Planning Application Ref: AB/60/17/PL [3] – all current comments added in blue typeface (prev in red for AB/130/16/PL).

Location: Land to rear of 74 & 76 Canada Road, Arundel

Description of works: Erection of 1 No 3 bed dwelling & new garage and parking and crossover

Consultant Arboriculturist

dwg no: PR117371-03D

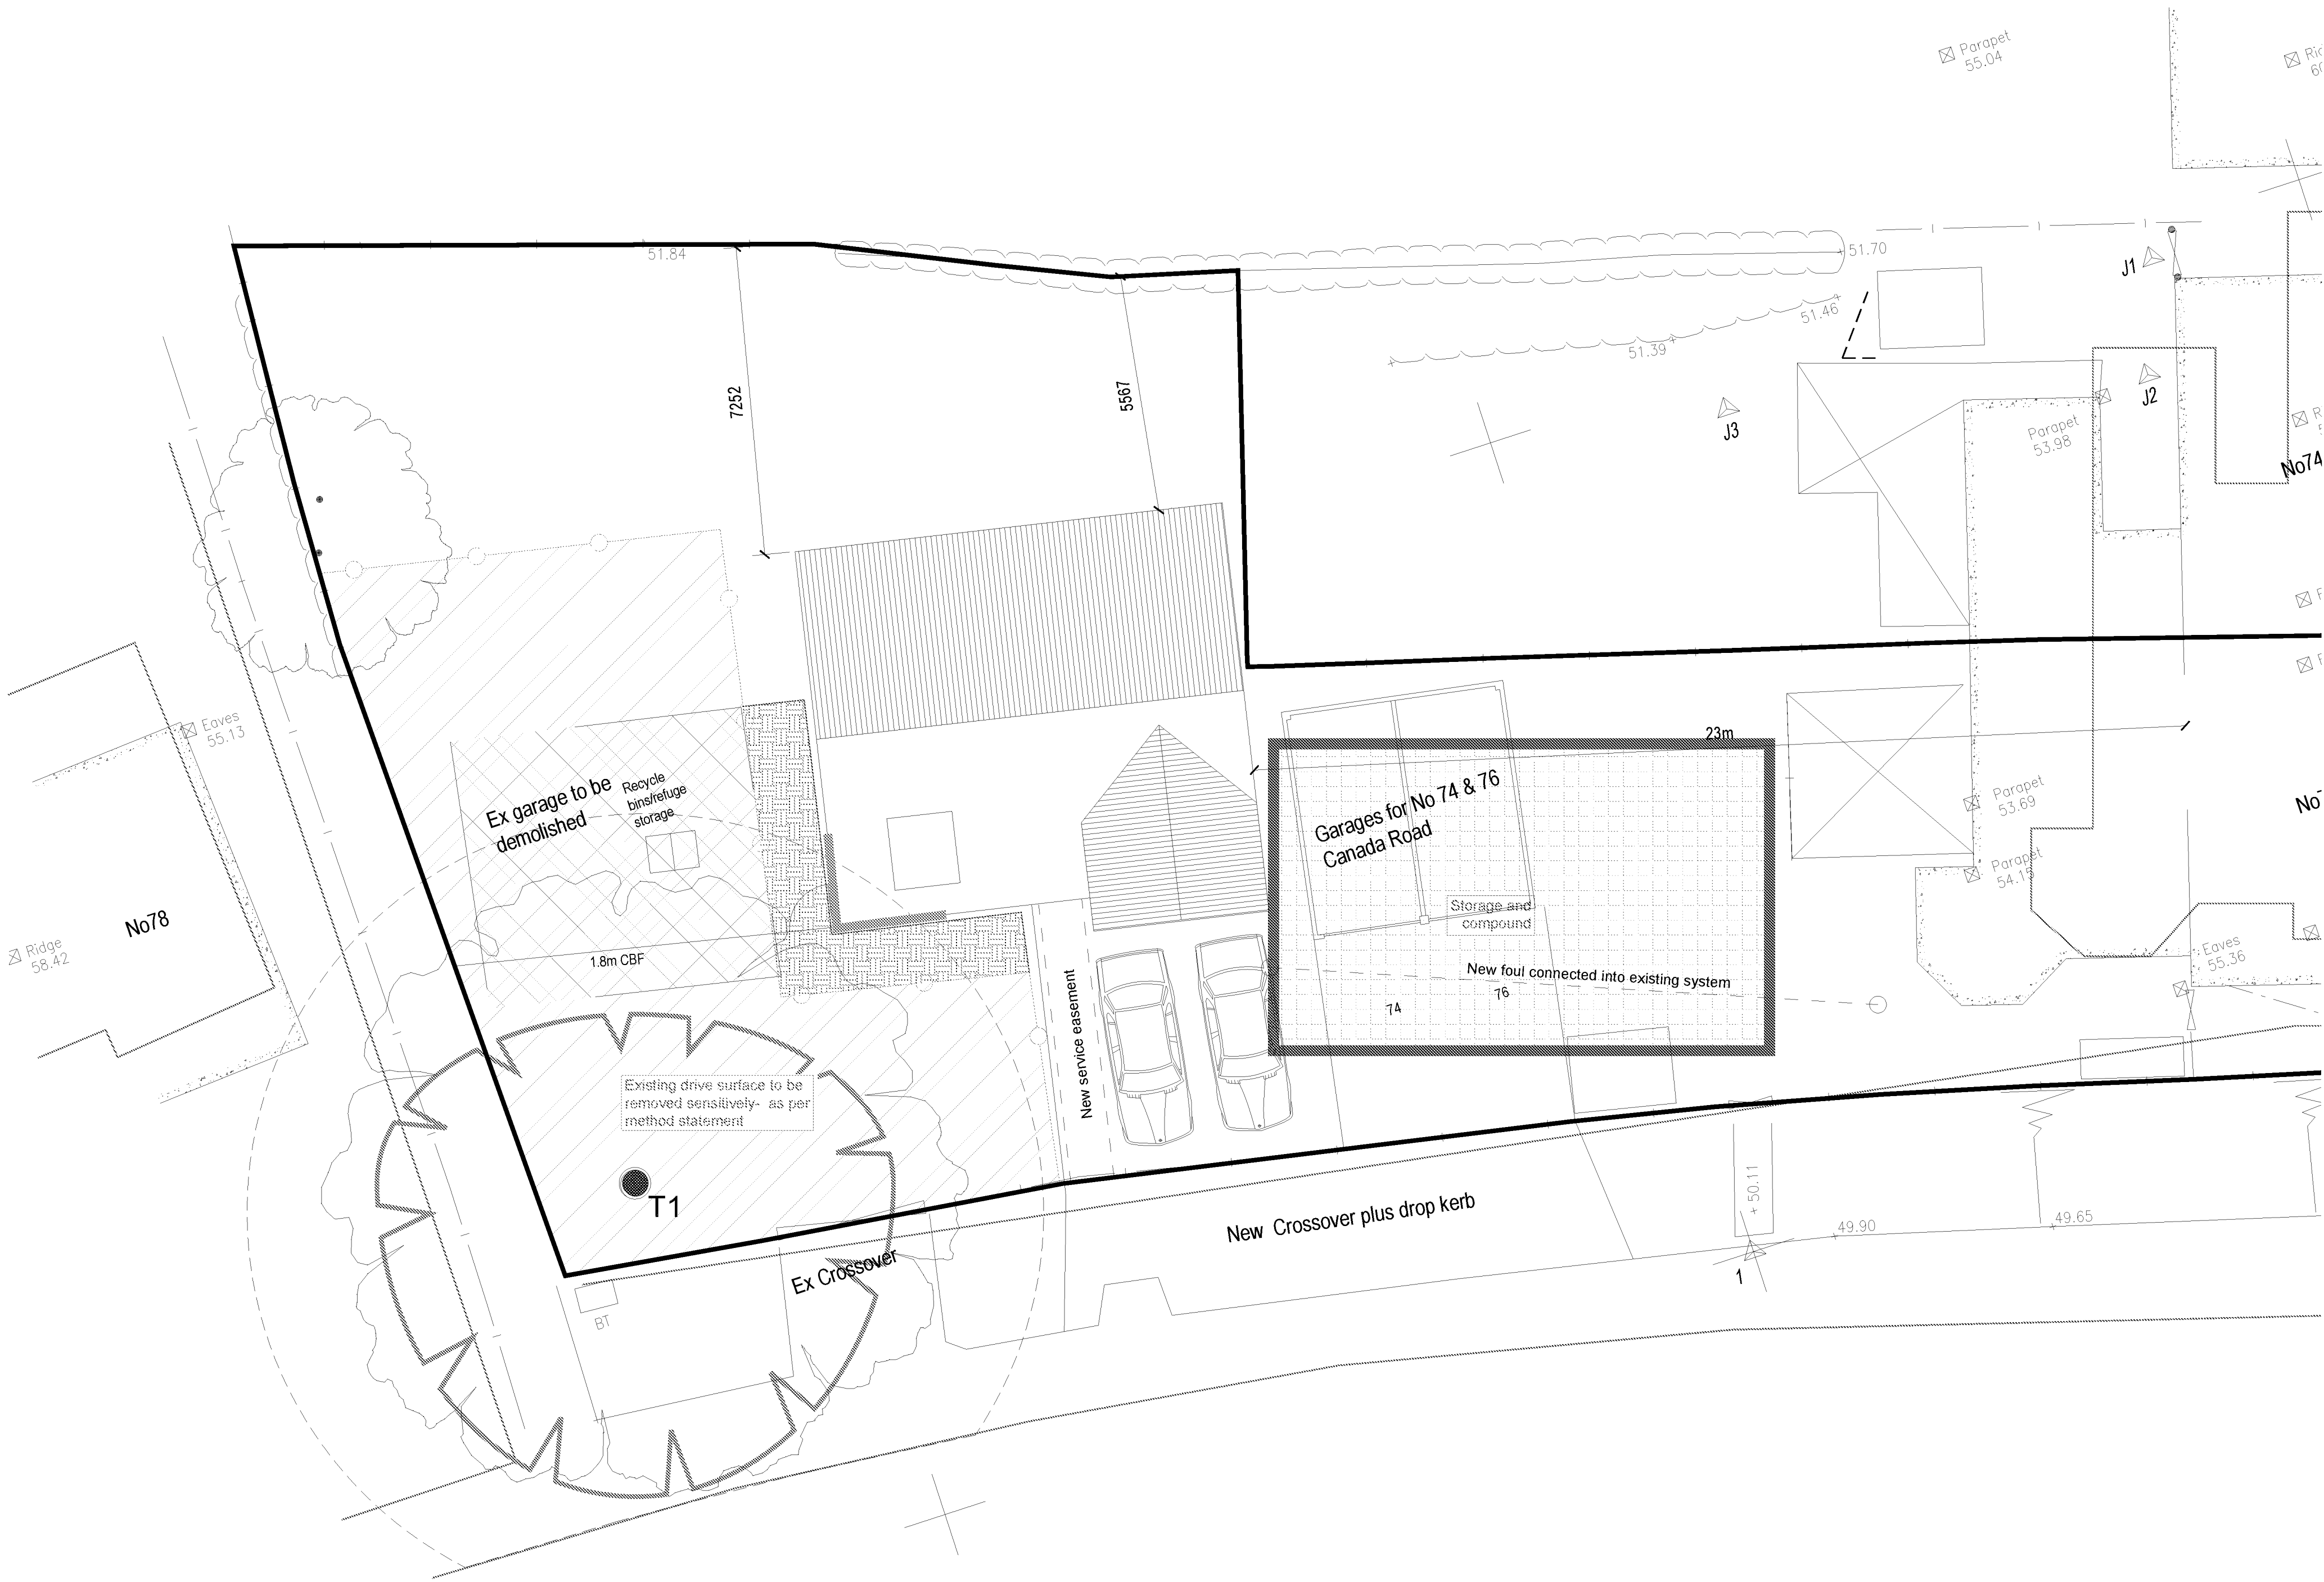
- At 9.2 It states that '*No details of Site Storage, parking, welfare unit location etc are available at the time of writing*' – On a site as small and tight to work on as this we would not let this be subject to a later Condition of Planning when it may be too late to get it right and we would be under pressure to then relent and let it all happen within the RPA – these details will be needed at the application stage. Reference has now been made to this at 8.1 of new report with an area shown on the Tree Protection Plan – which is satisfactory.

- A PRE-COMMENCEMENT Site Meeting is to take place between the Arun DC Tree Officer and the Arboricultural Consultant representing the site owners – at this meeting all protective fencing will be inspected along with ground protection measures – they will be assessed to verify that they are 'Fit for Purpose' as required under British Standard 5837:2012 and have been erected and positioned exactly as shown on the Tree Protection Plan Appendix A – Rev B. Feb2017.
